memorandum

re:	Geotechnical Response to City Comments
	Proposed Mixed-Use Development
	2 Robinson Avenue - Ottawa, Ontario
to:	Place Dorée - Mr. Mike Marcella – mike@placedoree.com
cc:	Prince Developments – Mr. Kiren Waugh – <u>kwaugh@princedev.com</u>
date:	July 28, 2022
file:	PG4811-MEMO.03

Geotechnical Investigation Comments

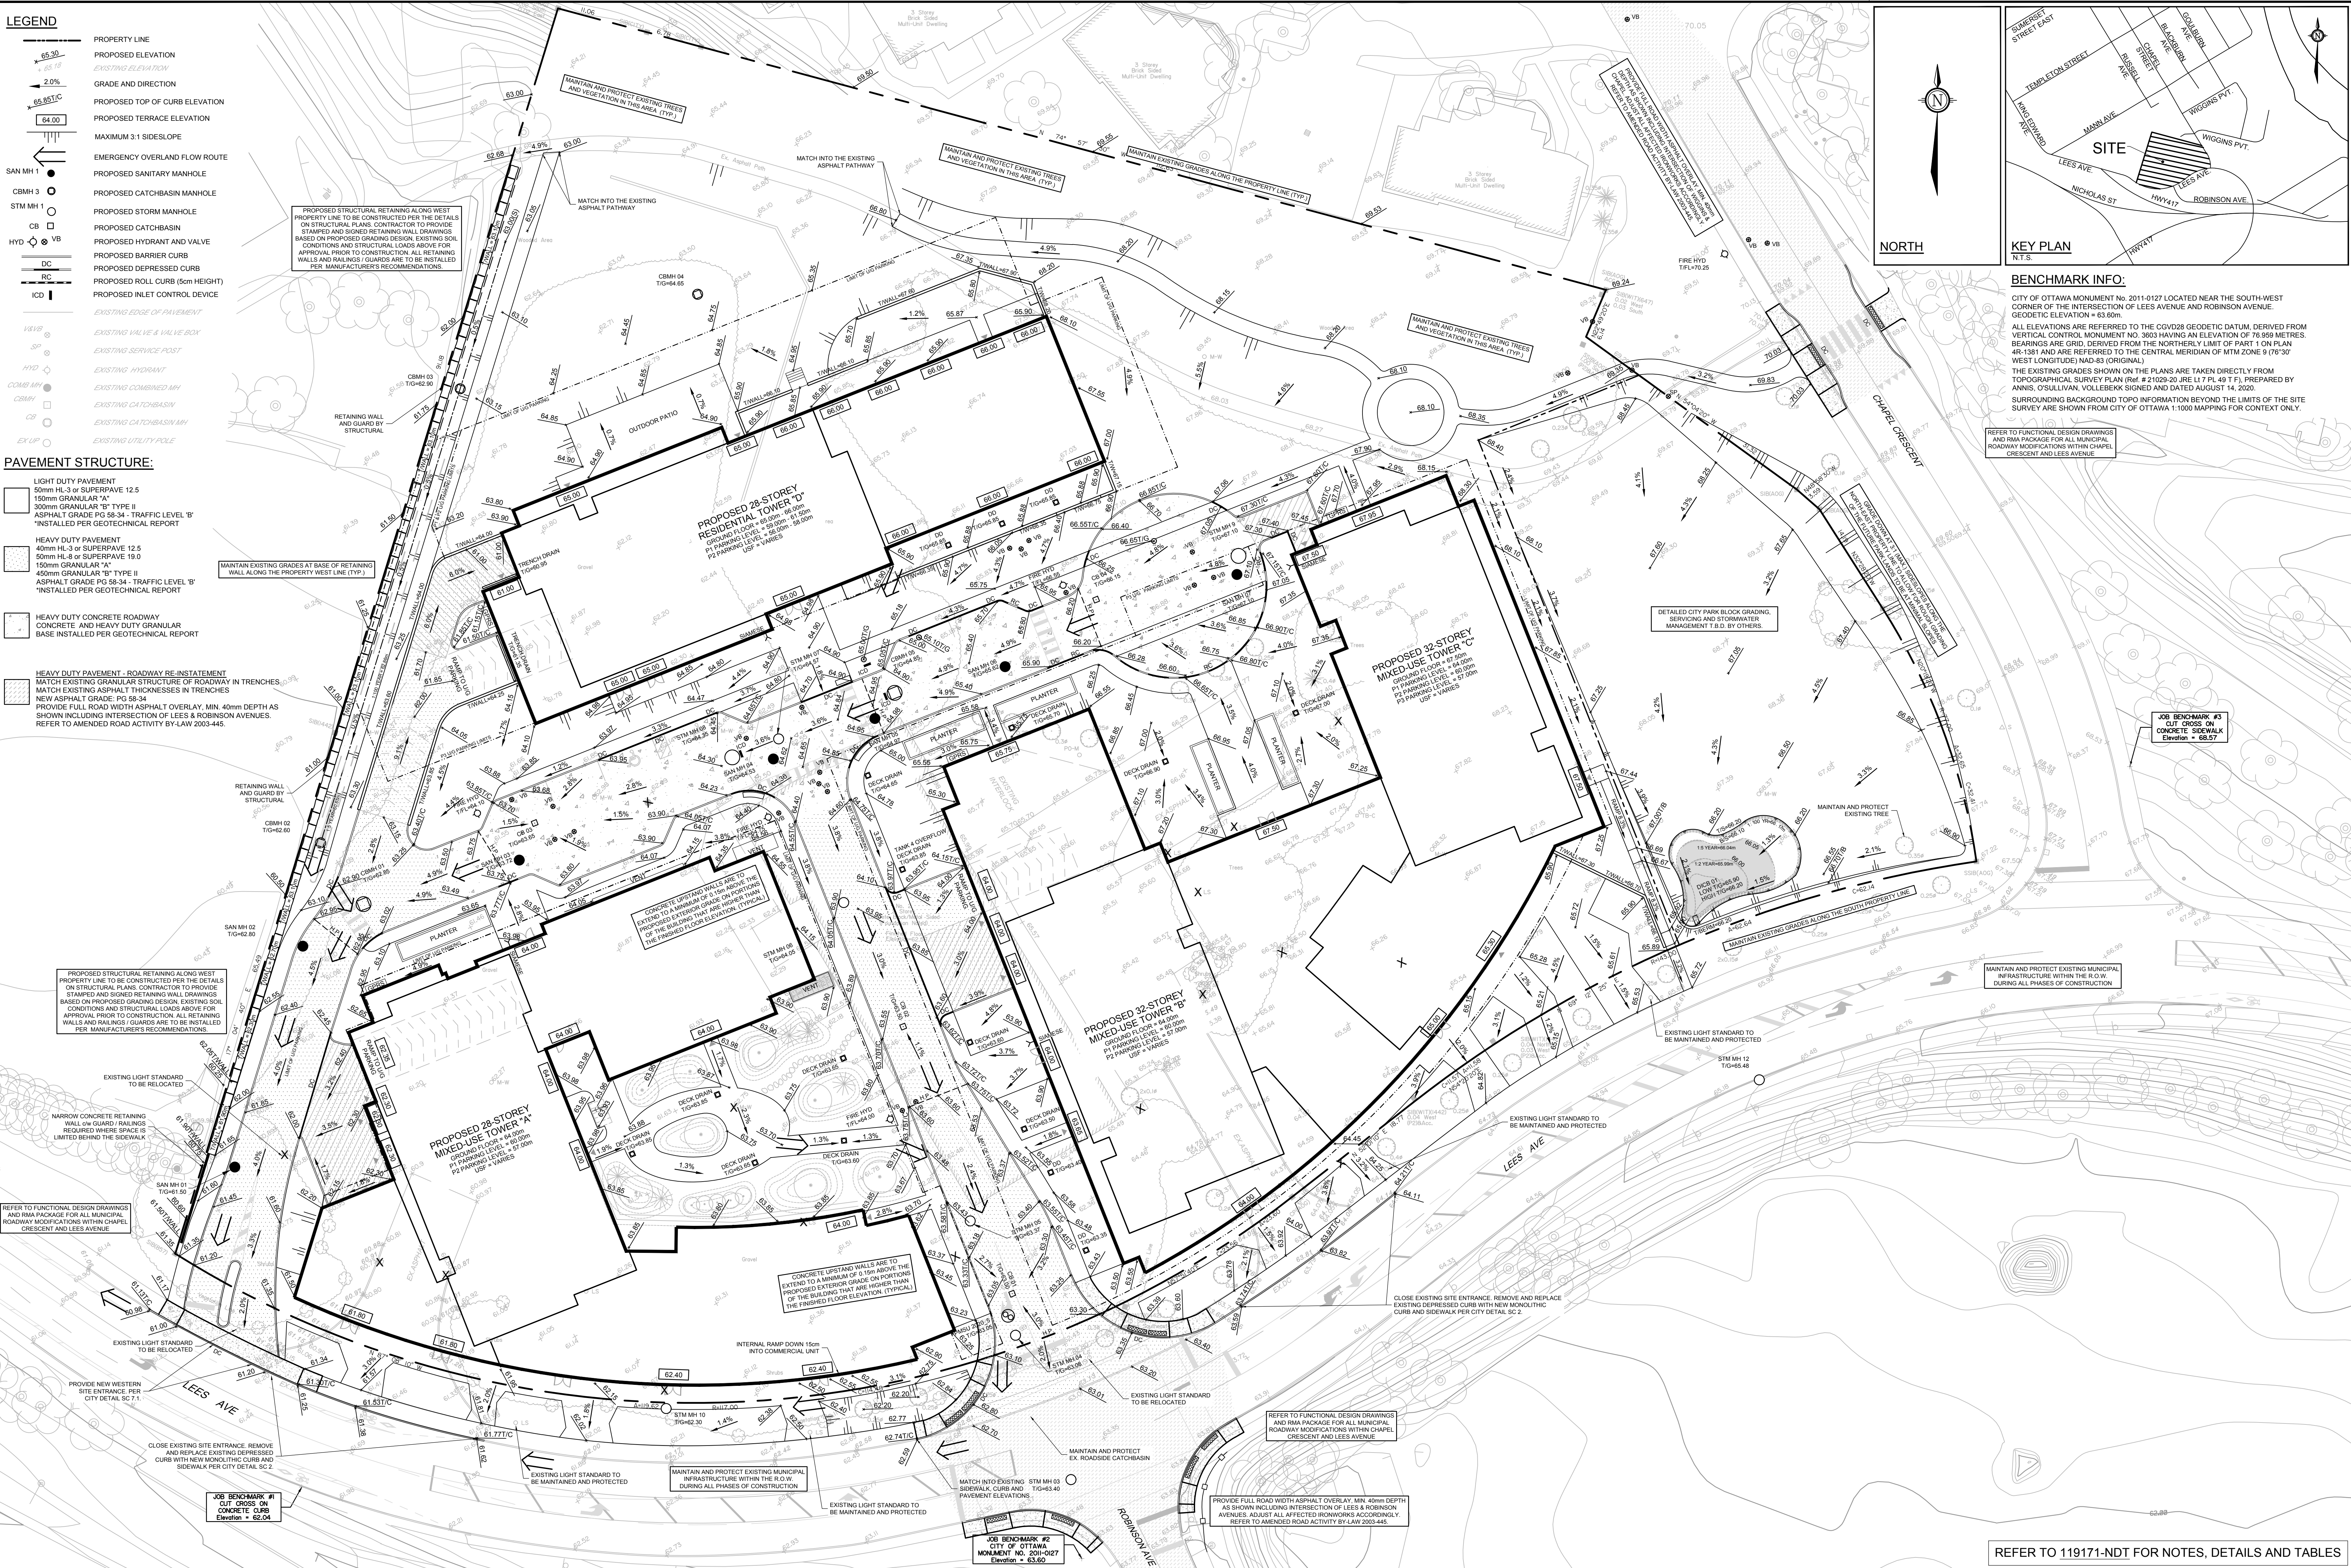
Comment 5: Please provide global stability review, as per the latest Memo.

Response: It should be noted that Paterson has not completed a detailed retaining wall design to date for the subject site and the following information is not representative of the final retaining wall design. The global stability review was prepared based on an anticipated retaining wall design for the proposed site grading as shown on the following drawing prepared by NovaTech:

□ Grading Plan – 2 Robinson Avenue – Project No. 119171 – Drawing No. 119171-GR – Revision 2 dated March 30, 2021.

A minimum factor of safety of 1.5 is satisfactory for static conditions for the global stability of the subject retaining wall.

Based on the results of the analysis, the factor of safety for the proposed condition exceeds 1.5. It should be noted that as a conservative measure, the groundwater level for the global stability of the retaining wall assumed full saturation of the retained soil. The soil parameters utilized in our global stability review are outlined on Figure 2 – Global Stability Analysis for Retaining Wall.
